REQUEST

Current Zoning: R-20MF (multi-family)
Proposed Zoning: MUDD-O (mixed-use development district, optional) with 5-year vested rights.

Approximately 8.55 acres located on the east side of Old Providence Road and west side of Providence Road, north of River Oaks Lane.

The petition proposes a multi-family development containing up to 380 dwelling units on a site that is currently developed with an apartment complex.

SHEET NUMBER: RZ2-00

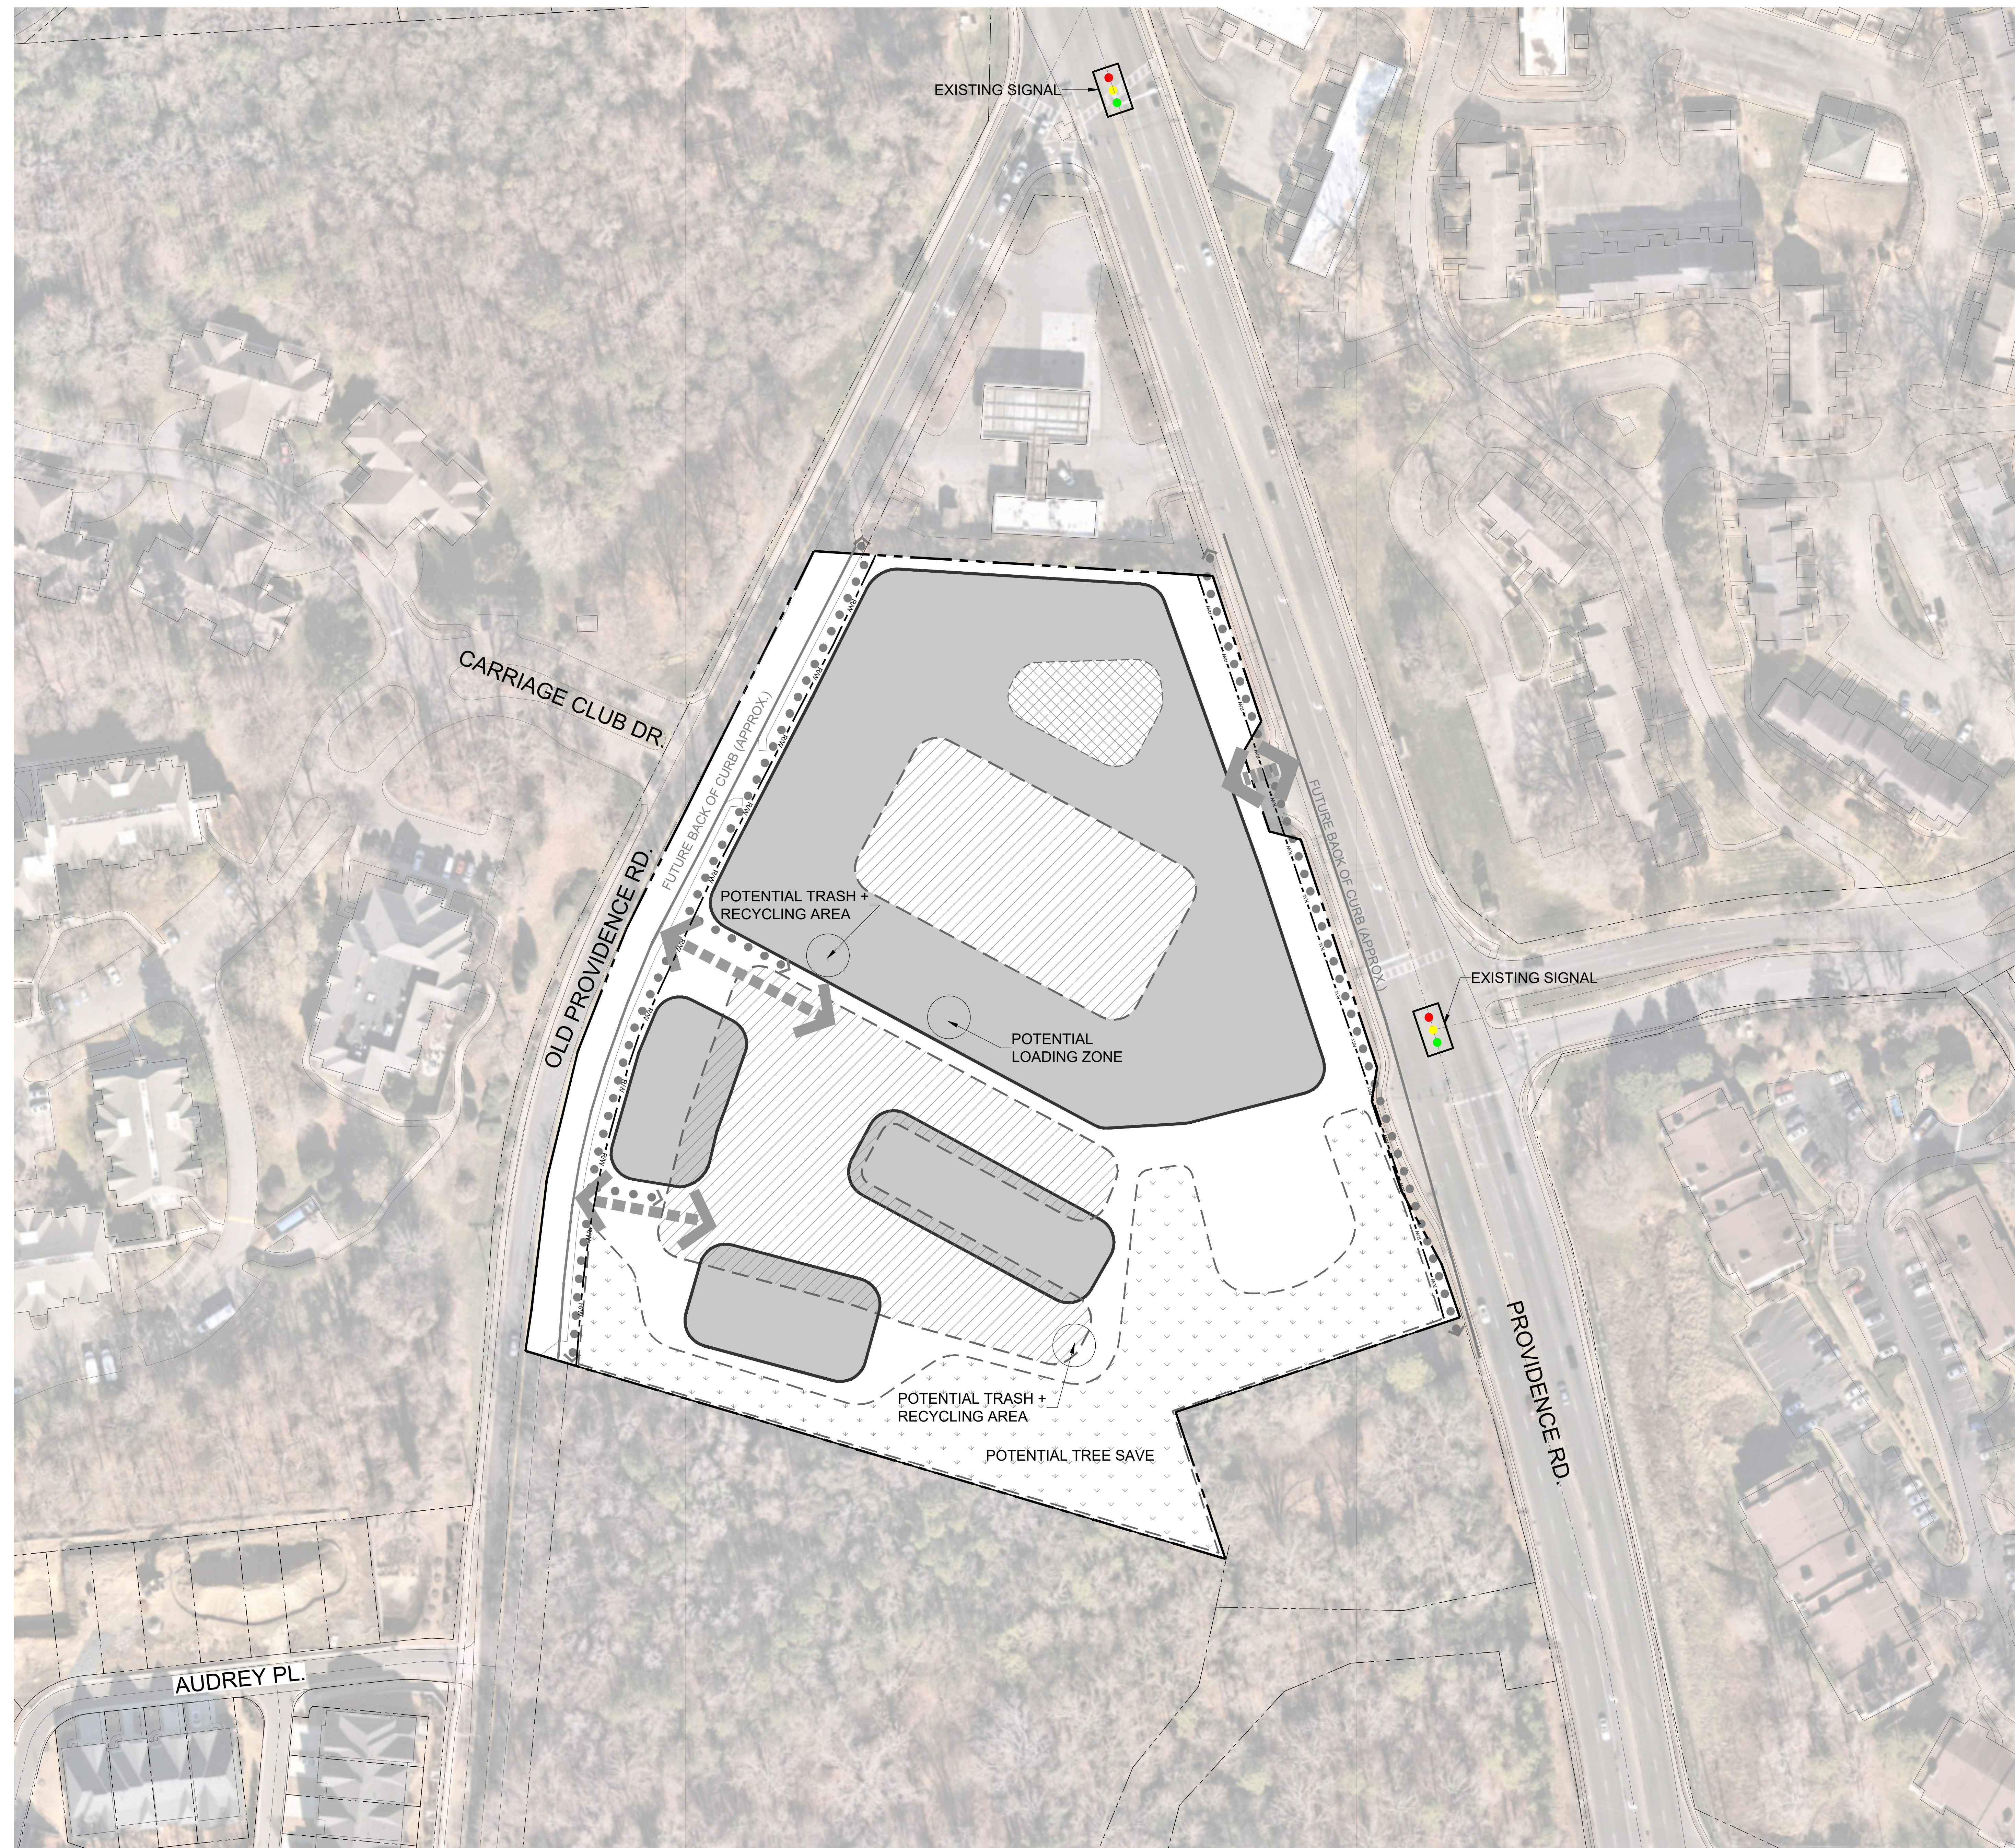
11. Entitlement Services: Show an approximate location of the pedestrian connection on the site plan. Coordinate this location with petition 2023-039.
